North Lincolnshire Council

Planning Inspectorate's Reference: EN010148

Subject: Application for an Order Granting Development Consent for the Tween Bridge Solar Farm

DEADLINE 5 SUBMISSION

Figure 6.4 Landscape and Visual Mitigation Strategy

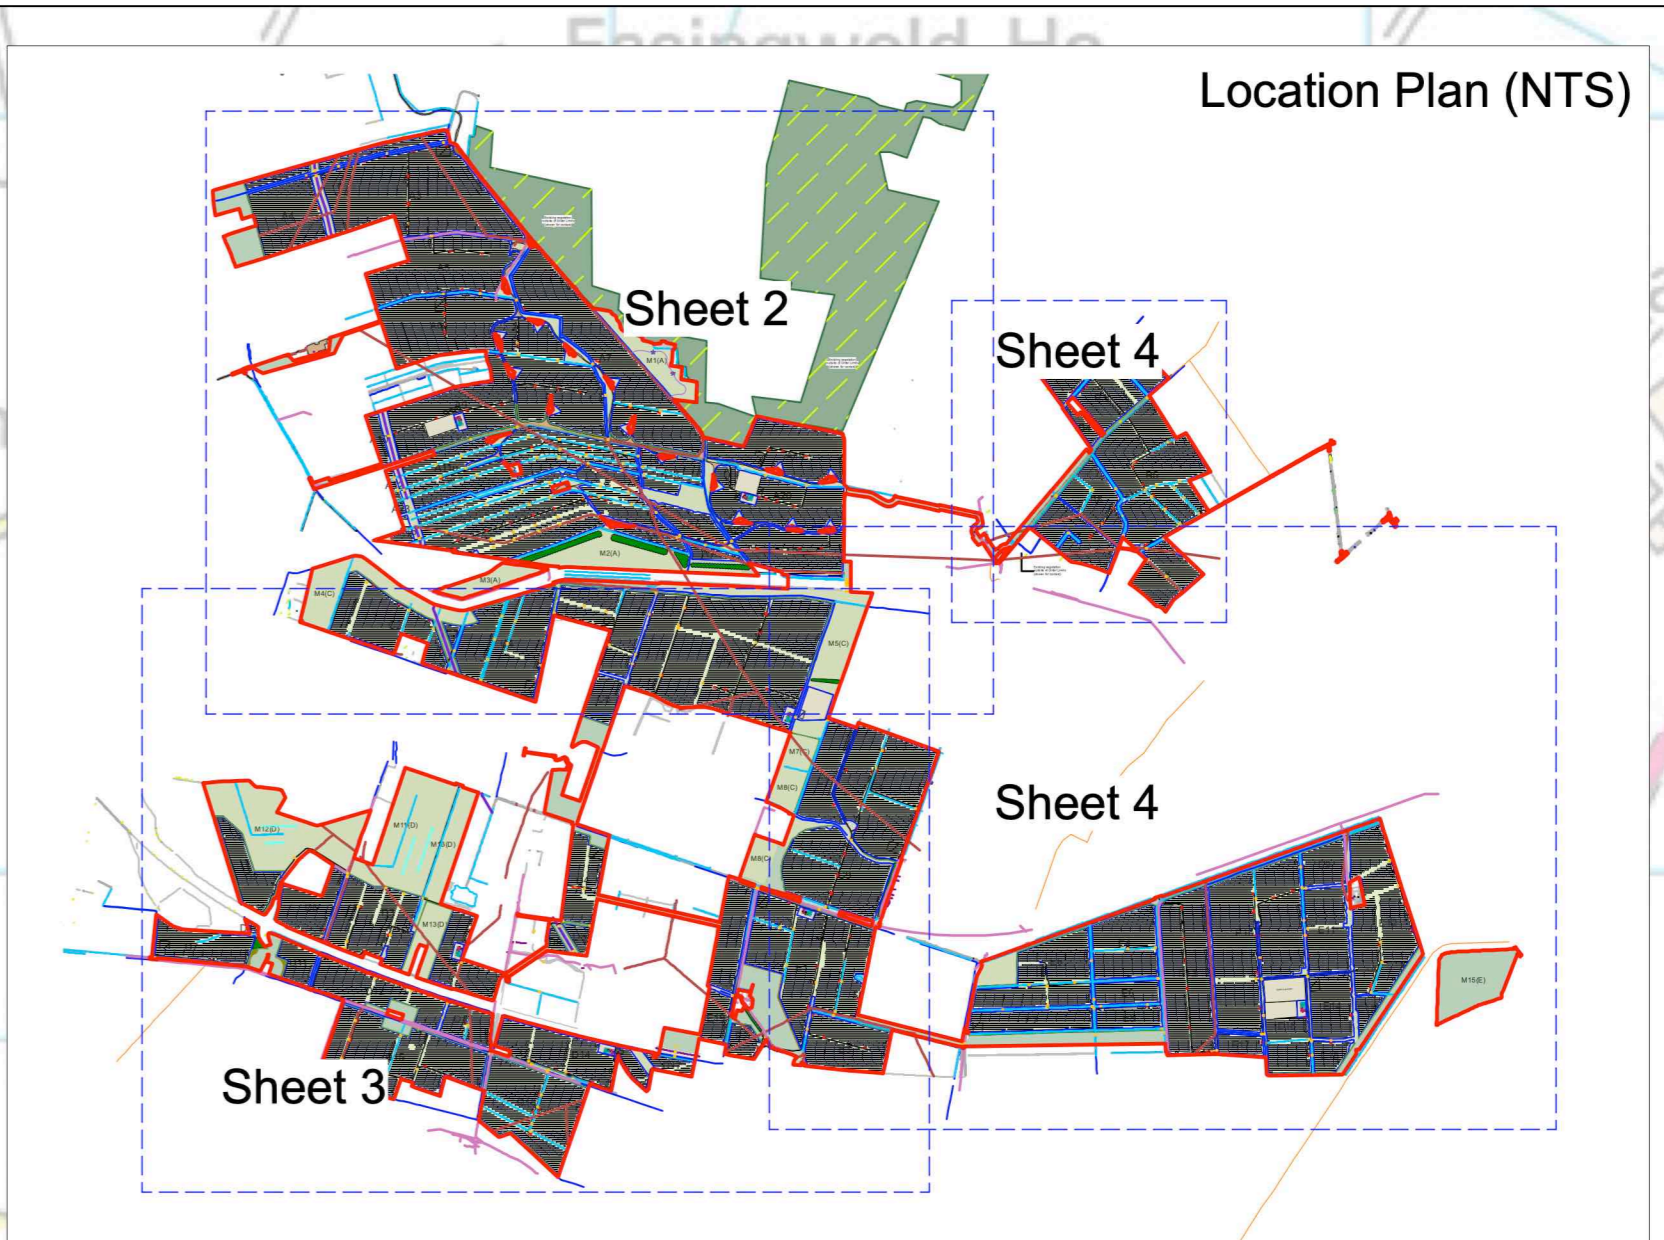
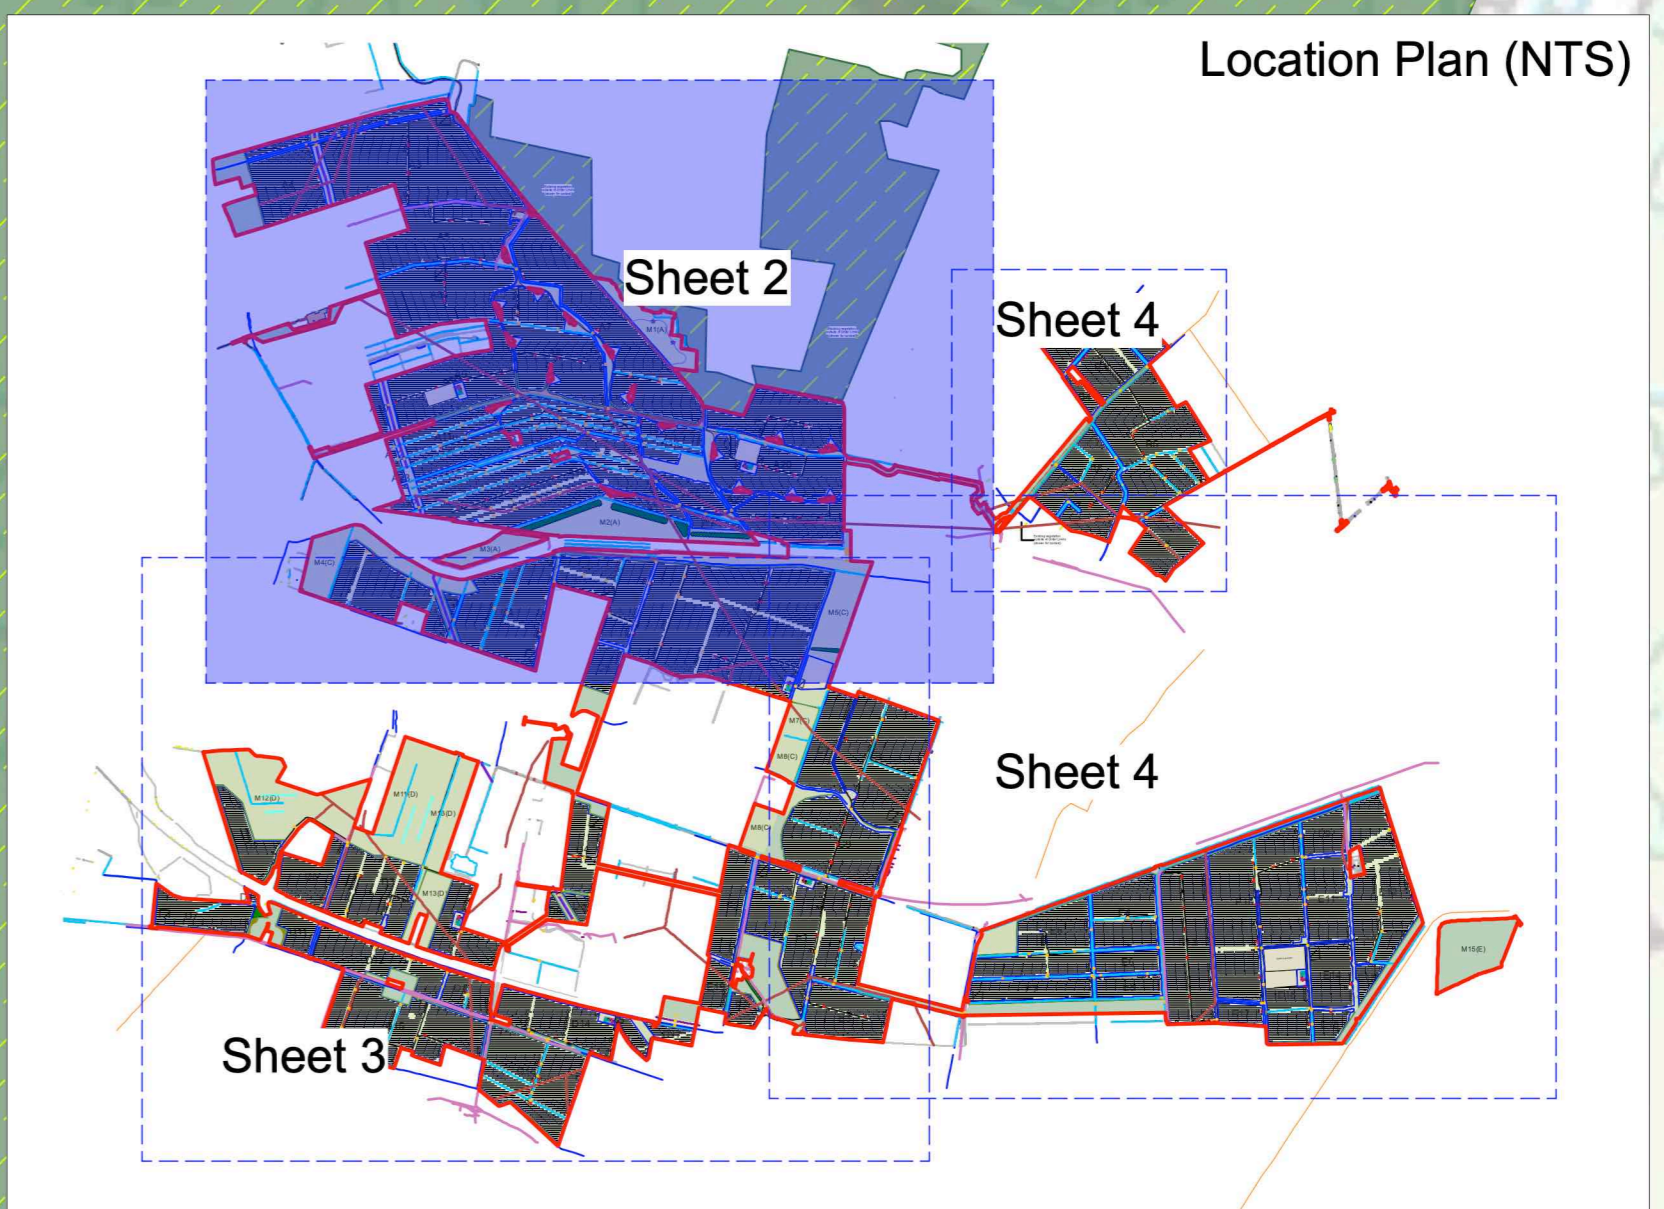
Ref	NLC Deadline 3 Comment	Applicant's Response	NLC Further Comments
		Revision 4], ES Figure 6.4 Landscape and Visual Mitigation Strategy [Document Reference 6.4.6.4 Revision 5] and the Outline Landscape Ecological Management Plan [Document Reference 7.6 Revision 5].	
NLC24	Environmental Statement Chapter 6: Landscape and Visual (Tracked) (Rev 3) [REP2-034]: The Council notes that additional description has been added regarding the construction compounds; additional assessment has been included regarding the construction effects on visual receptors; significant Construction effects are now stated upon footpath and road users. It is also noted that there are no updates made to the landscape character assessment or to provide additional description re value and sensitivity.	ES Chapter 6 – Landscape and Visual [Document Reference 6.2.6 Revision 4] has been updated at Deadline 4 in regard to the landscape character assessment to account for the Isle of Axholme and Hatfield Chase Landscape Partnership Assessment (2014) and the North Lincolnshire Landscape Character Assessment (2021). Further detail of the assessment of landscape value and sensitivity has been added to the updated ES Chapter 6 – Landscape and Visual [Document Reference 6.2.6	NLC notes this comment and will respond as soon as possible once it has been able to fully review the updated ES Chapter 6.

Document Reference: 6.4.6.2

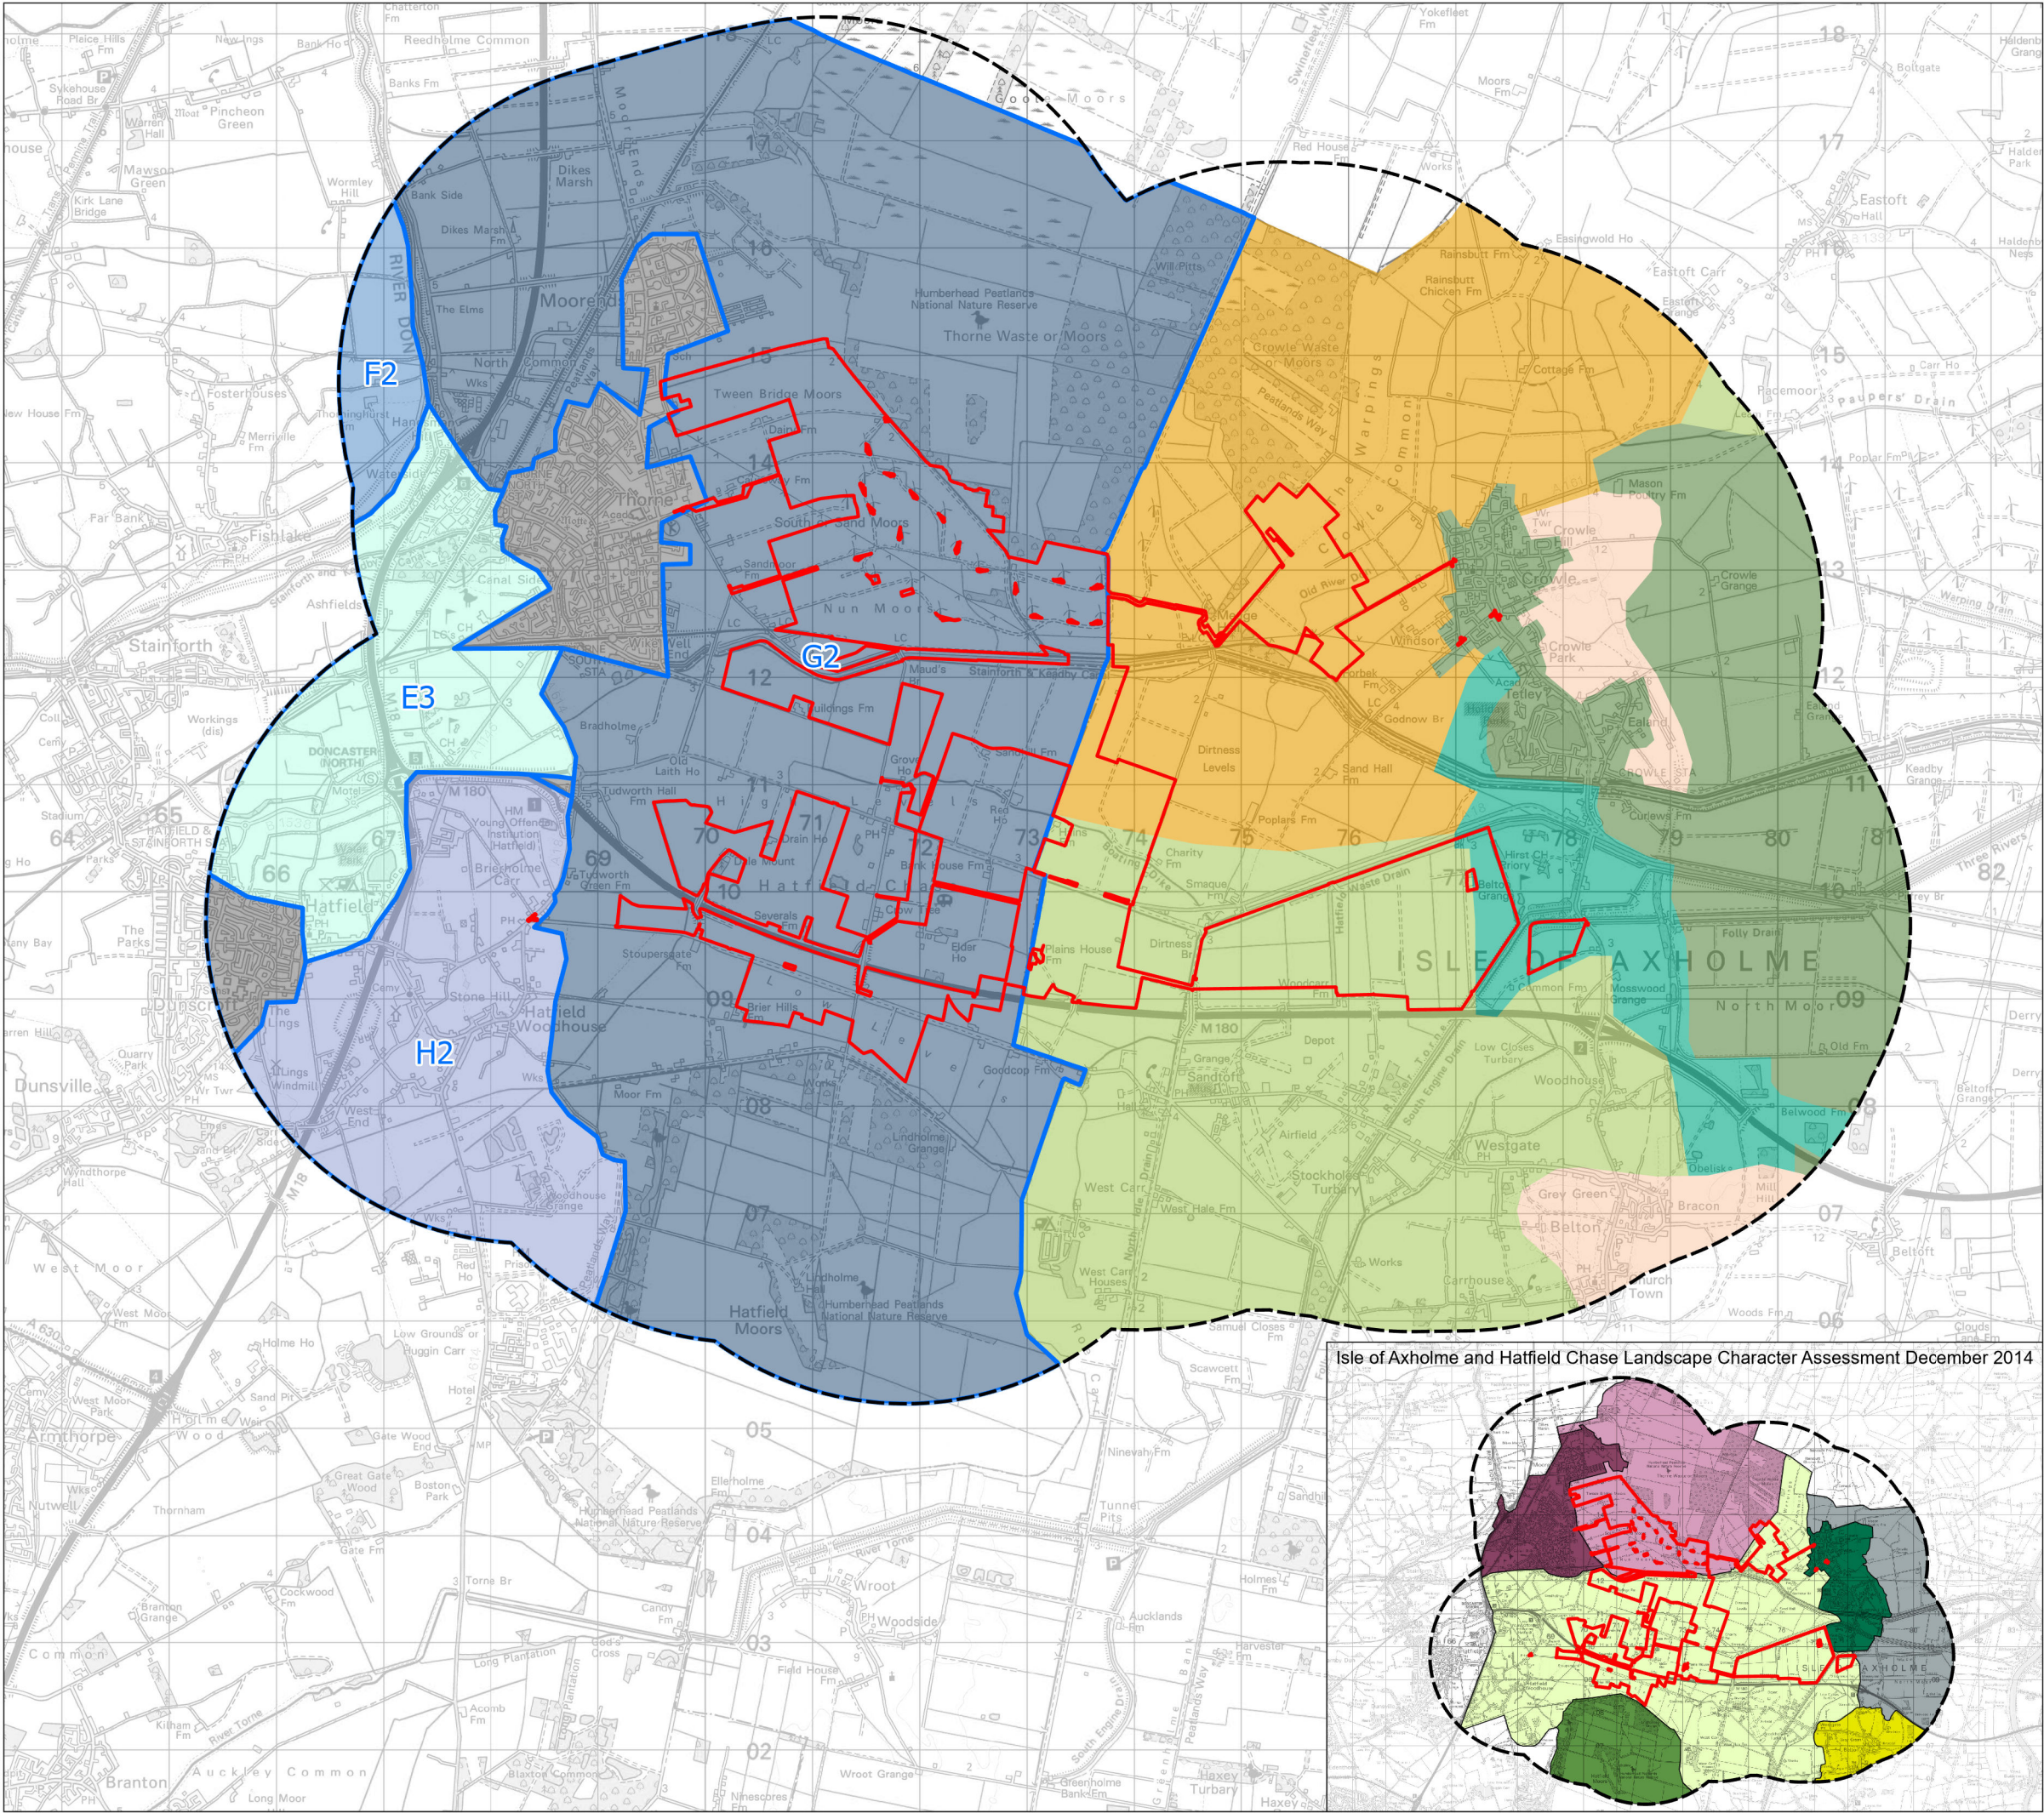
Ref	NLC Deadline 3 Comment	Applicant's Response	NLC Further Comments
	Includes the North Lincolnshire Landscape Character assessment, North Lincolnshire Council, JBA (2021) which forms part of the evidence base to the emerging local plan. These more contemporary documents should have been considered when informing the baseline studies for the assessment. The Council would therefore welcome a more Detailed assessment of the effect of the proposals on landscape character, informed by current available studies at a more detailed scale.	to ES Chapter 6 Landscape and Visual [Document Reference 6.3.6 Revision 4] to reflect the Isle of Axholme and Hatfield Chase Landscape partnership Assessment (2014) and the North Lincolnshire Landscape Character Assessment (2021) and has been submitted as part of Deadline 4.	requested) and the value of the landscape outside national designations in accordance with TGN02-21. Nevertheless, it appears that the landscape character has been undervalued and underplayed in the LVIA. • Within the LVIA, baseline information has been added and then a statement on the susceptibility, value and sensitivity for these additional character areas made. However, no explanation is included on how the conclusion on value, susceptibility and sensitivity has been made. All the character areas added have been given a medium value, medium susceptibility to

Ref	NLC Deadline 3 Comment	Applicant's Response	NLC Further Comments
			the development and medium sensitivity. For example, Hatfield Chase Levels LCA (from the 2014 character assessment) is summed up in LVIA para 6.4.51 : <i>'Hatfield Chase Levels LCA is considered to be of medium sensitivity based on medium susceptibility and medium value'.</i> The description prior to this statement, extracted from the LCA text, includes the bullet points – 'Important historic landscape', 'rare historical settlement pattern'; 'strongly geometric landscape, dominated by big skies with a marked sense of space'. It is hard to see how an area with that

Ref	NLC Deadline 3 Comment	Applicant's Response	NLC Further Comments
			description would not be considered high value. It is also difficult to understand why it would not have a high susceptibility to this type of development when a large portion of the proposals lie within it. This would result in a high sensitivity. • Again, The Trent Levels – flat Open Remote Farmland (in the NLC study) includes key characteristics including 'the landscape has been described as remote, although this now feels to have been eroded due to the significant vertical intrusion of the windfarm to the west of Medge Hill' – this demonstrates that the landscape is already under pressure and changing as a result of
